Rezoning Transportation Analysis

Petition Number: 2023-124

Date	Description
11-21-23	First Review (IW)
12-19-23	Second Review (KC)
01-22-24	Third Review (IW)
02-21-24	Fourth Review
03-04-24	Trip Generation Update
04-24-24	Fifth Review (IW)
07-01-24	Sixth Review (IW)

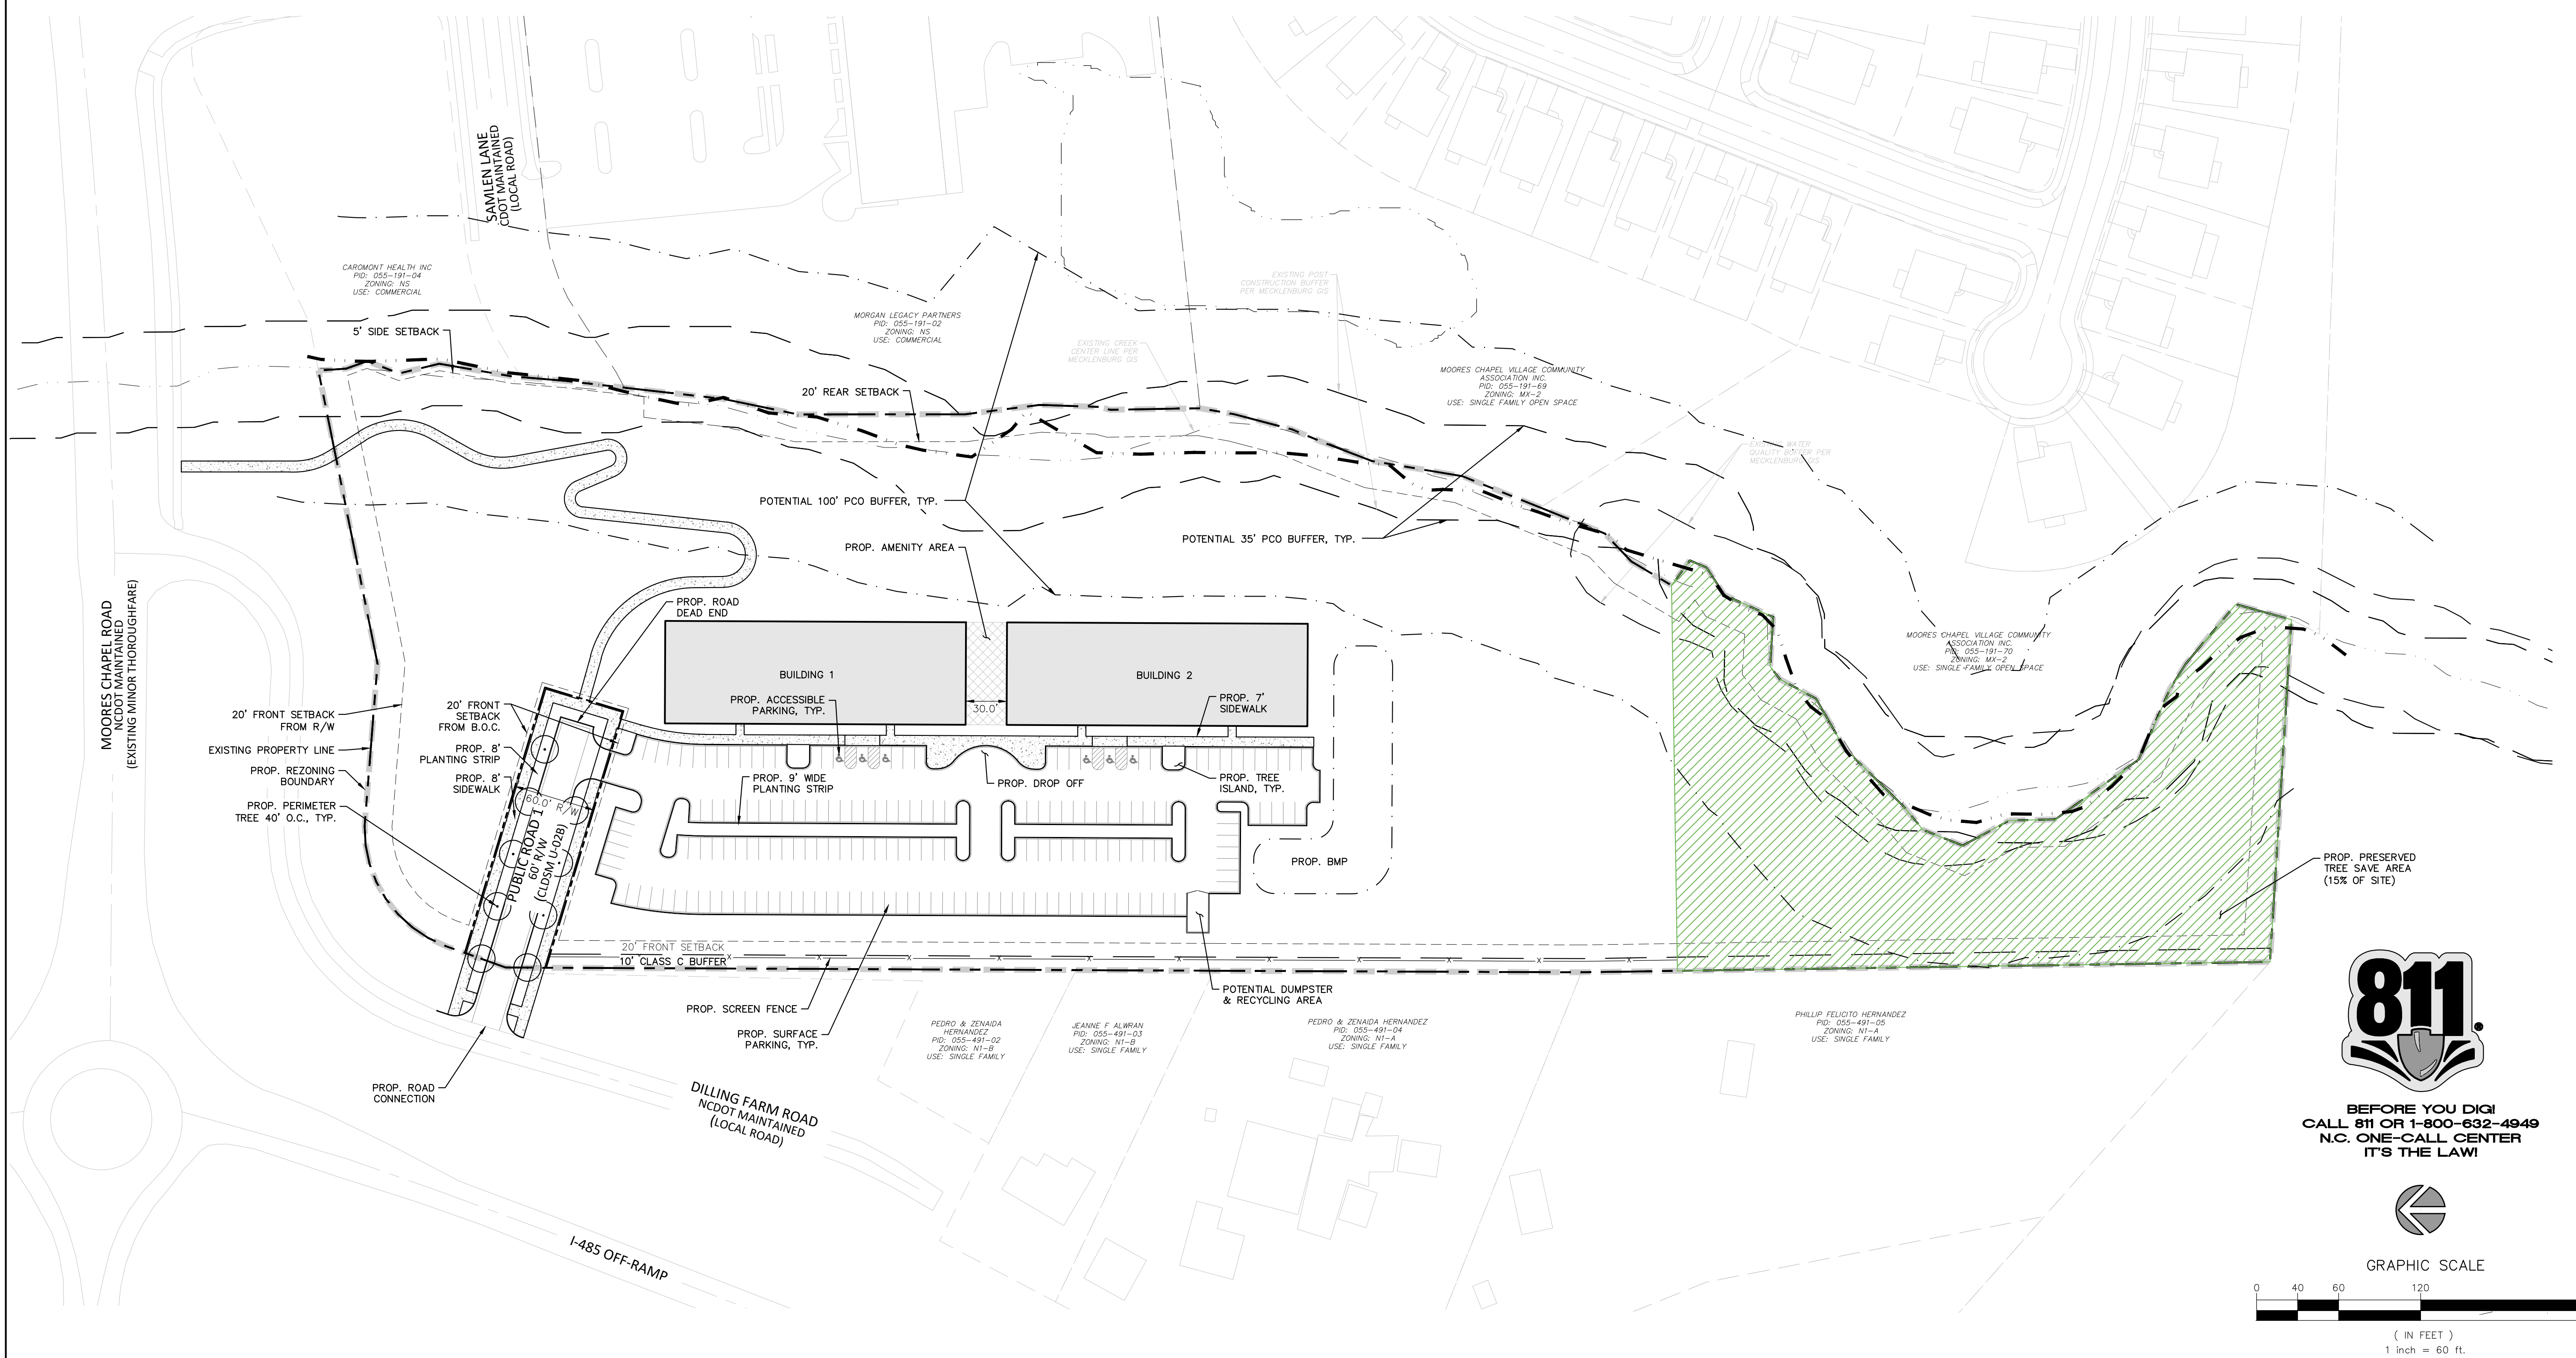
a. ~~**Moore's Chapel Road:** Label and dimension the location of future curb and gutter to be 38' from centerline.~~

b. ~~**Dilling Farm Road:** The location of the future back of curb and gutter to be 17.5' from centerline. The sight plan is to commit to installing as well.~~

~~Label and dimension the curb and gutter from the centerline for each road on the site plan.~~

3. ~~Revise site plan and conditional note(s) to commit to dedicate 33.5' of right-of-way from the road centerline along Dilling Farm Road. The site plan shall label and dimension the right-of-way from the road centerline.~~

5. **Outstanding Comment 11-21-23:** ~~Revise site plan and conditional note(s) to commit to constructing an 8' planting strip and an 8' sidewalk per Article 33 of the UDO and CLDSM U-03A1 along Dilling Farm Road.~~
Clarifying Comment: ~~Site plan does not show 8' planting strip and an 8' sidewalk per Article 33 of the UDO and CLDSM U-03A1 along Dilling Farm Road.~~

6. ~~Revise site plan and conditional note(s) to commit to making "Public Road 1" a private road per coordination with Subdivision.~~
7. ~~Add a conditional note specifying "the Petitioner shall dedicate and convey in fee simple all rights-of-way to the City before the site's first building certificate of occupancy is issued. CDOT requests rights-of-way set at 2' behind back of sidewalk where feasible."~~
